Application number: 2019/93157	
What is the application for?:	Alterations to convert former restaurant to 3 apartments (within a Conservation
Address of the site or building:	3-5, St James Street, Batley, WF17 5SA
Postcode:	WF17 5SA

SITE PLAN
 SCALE: 1:500

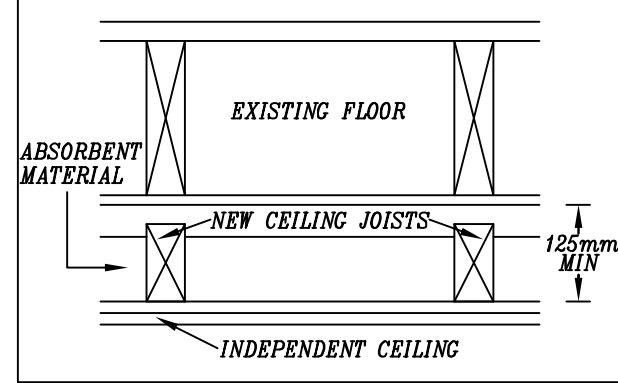
Type of comment: A general comment
<p>No objection to the flats themselves. However the boundary on the plans seems to include an area currently used for delivery access and bins. The businesses who use this courtyard could be adversely affected if the flats are marketed with parking. The plans do not state this either way. Also flat is let on the provision of two parking spaces. Any additional cars would jeopardise access. I would question how long any tenants of these flats would tolerate no car parking before they try to use an already congested area.</p>
